Online Comment

Application H08-0954-25
Location Riseholme Farm Gosberton Risegate PE11 4ET
Proposal Proposed Detached 4 Bed Dwelling

Name Imogen Colenutt, Assistant Conservation Officer
Address Council Offices The Hub Mareham Rd LN9 6PH

SHEET  
**Proposed Garage Elevations**

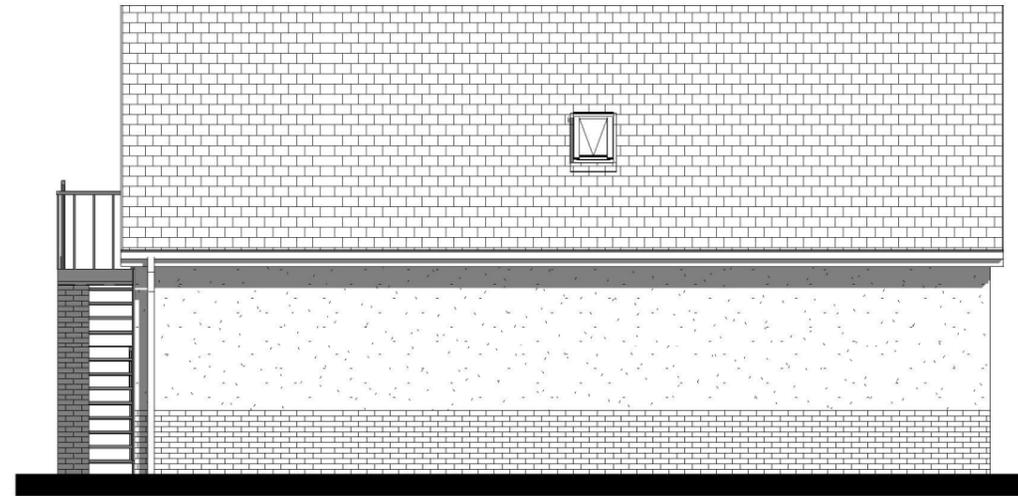
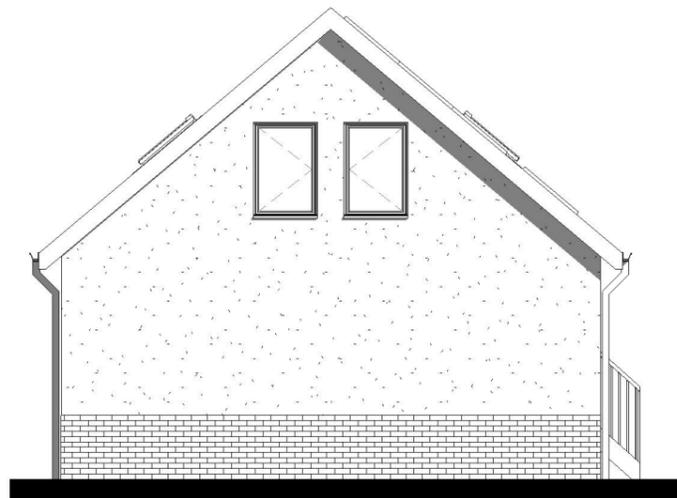
No further comments on heritage grounds. The massing of the garage does look rather large in proportion to the house, especially as the front elevation is now much more visible.
